Project Name : Land Adjacent to 21 Greencourt Drive, Bersted

Job No : 24-277

Note Title : Drainage Strategy Technical Note

1.1.2 The proposal comprises a residential development of two dwellings, including the creation of new vehicular access, landscape planting, surface water attenuation and associated infrastructure. The Arun District Council (ADC) planning application number is BE/70/24/PL.

4.2.1 The proposed surface water drainage strategy is shown in **Drawing 24-277-004**.

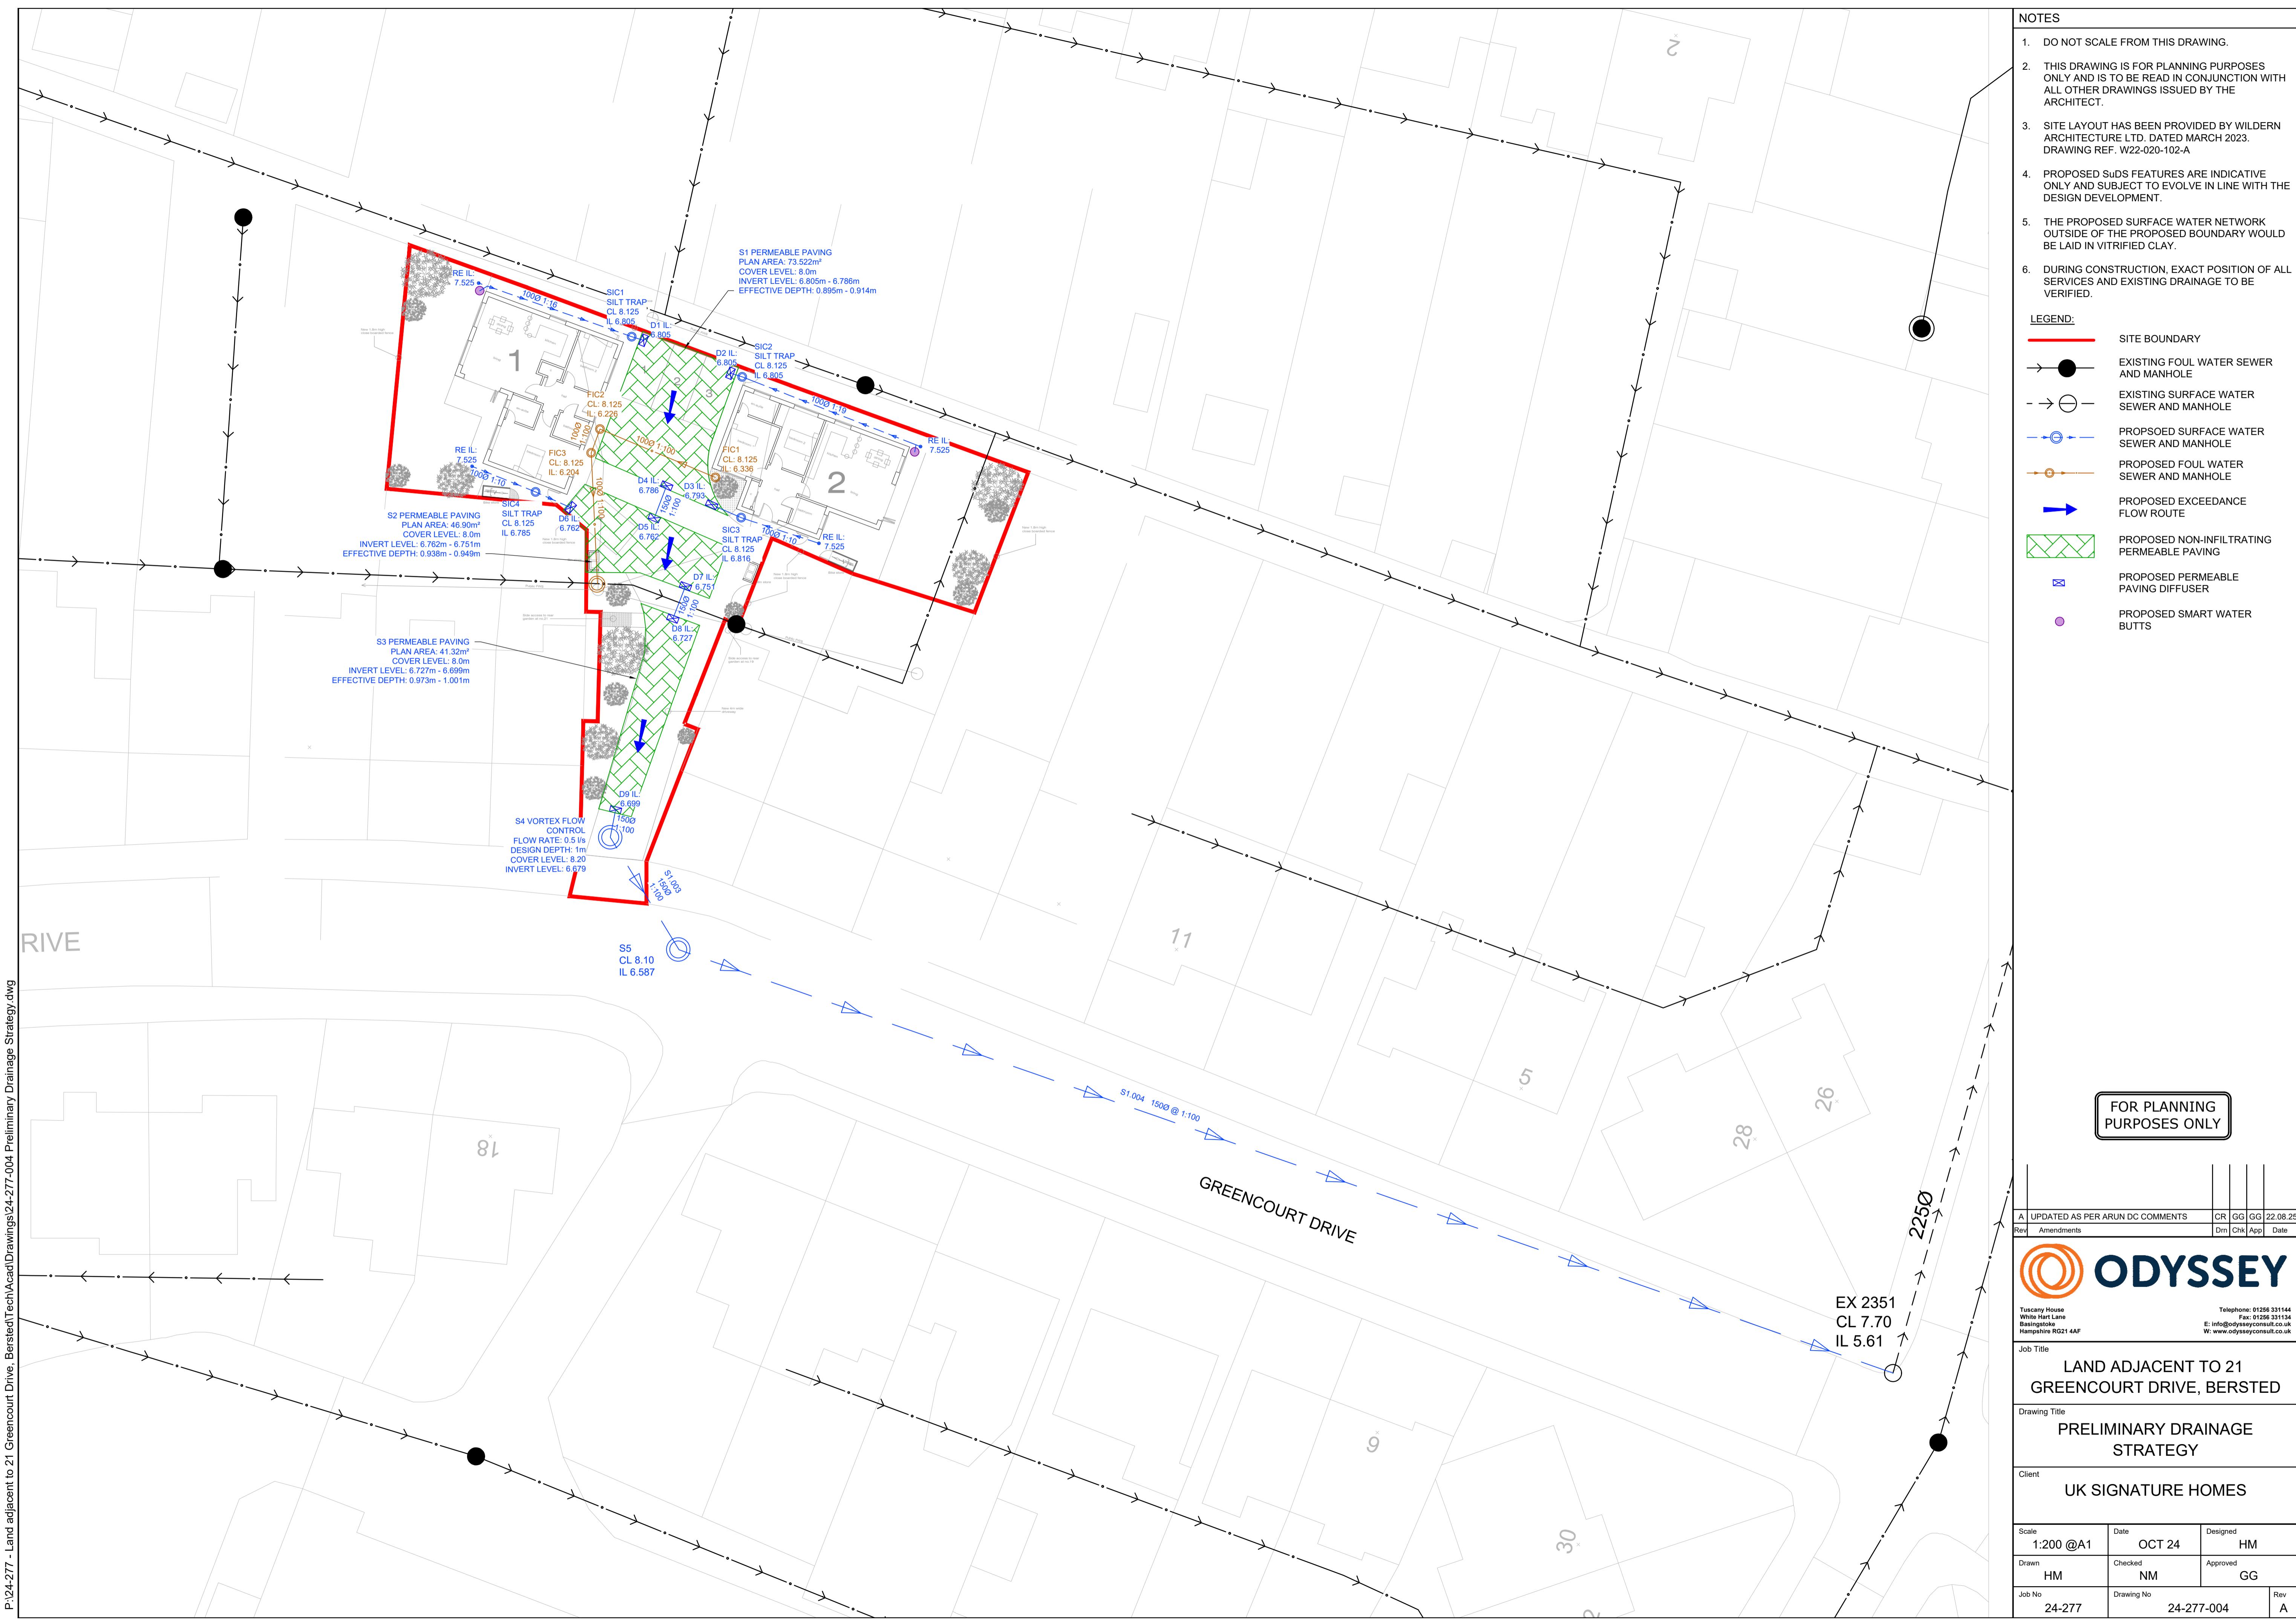
Insufficient information regarding surface water drainage has been submitted to evidence that flood risk will not be increased as due to the proposed development.

The only information relating to surface water drainage is in the application form, where it is indicated that the site will drain surface water via soakaway. We are supportive of this strategy, however no evidence has been submitted to show that infiltration is viable on the site. Ground conditions and infiltration potential are variable in Bersted. Infiltration can be possible, but in parts, groundwater can be high or infiltration rates so low as to make infiltration unviable.

1. Infiltration – not investigated.
2. To a watercourse – none available.
3. To a surface water sewer – none available in immediate vicinity – closest mapped surface water sewer is on South Way, it is unclear if a gravity connection can be achieved.
4. To a highway drainage system – As this is a private network, permission cannot be assumed. Generally, applications to connect surface water to highway drainage are strongly resisted.
5. To a combined sewer – none available.

Surface water must not be discharged into the foul sewer. The foul sewer is not a recognised disposal location in the SuDS Manual, Approved Document H, or the NPPG [Flood risk and coastal change para 056]. It is important to recognise that the foul and combined sewer networks are defined by the public sewer records held by Southern Water Services Ltd.

1. Provide evidence of a sustainable surface water disposal location. Including but not limited to:
 - Winter groundwater monitoring and winter infiltration testing,
If infiltration is not viable then present evidence of this in addition to:
 - Permission in principle to connect surface water from the site to an alternative disposal location. Please note, evidence of permission to connect surface water to the Southern Water public foul sewer will not be acceptable.
2. Evidence that a sustainable surface water drainage design can be accommodated within the proposed site layout. This will require a drainage statement, supporting calculations and a preliminary drainage layout (including connection levels) as a minimum.

4.2.2 The ADC drainage hierarchy states that the most-preferred method of surface water discharge is “*discharge into the ground (infiltration)*”. The groundwater monitoring results indicate the highest level encountered was 1.40m bgl, and a 1m unsaturated zone would be required between the base of an infiltration device and the peak groundwater level. The attenuation storage would therefore need to be kept at a maximum depth of 0.40m in order to achieve the 1m unsaturated zone, and the area required to achieve sufficient storage at this shallow depth would not be feasible within the site layout.

4.2.3 Furthermore, a 5m infiltration buffer between an infiltration device and any building. There would be insufficient space to achieve the necessary attenuation on site once a 5m buffer has been applied to both the existing dwellings located to the east and the west of the site, as well as the proposed dwellings. As such, infiltration is deemed to be an unviable option for surface water disposal.

4.2.5 The next most-preferred method of surface water discharge is “*controlled discharge to a surface water sewer*”. It is proposed to connect flows to the Southern Water surface water sewer located to the south-east of the site.

4.2.6 It is proposed that surface water from roads and clean roofs would be conveyed to permeable paving within the shared surfacing serving the two dwellings. Flows would connect to the public sewer at a controlled rate. Owing to the very low QBAR greenfield runoff rate, it is proposed to discharge flows at 2l/s in order to reduce the maintenance burden associated with lower flows.

4.2.7 The permeable paving has been designed to accommodate a 1 in 100-year storm plus 45% to account for climate change in line with the latest guidelines. The calculations have been undertaken in Causeway Flow and incorporate FEH 2022 rainfall data. Cv values have been set to 1.0 as per ADC requirements, and no additional allowance has been included to account for urban creep owing to the restricted nature of the site. The Causeway Flow calculations are presented in **Appendix E**.
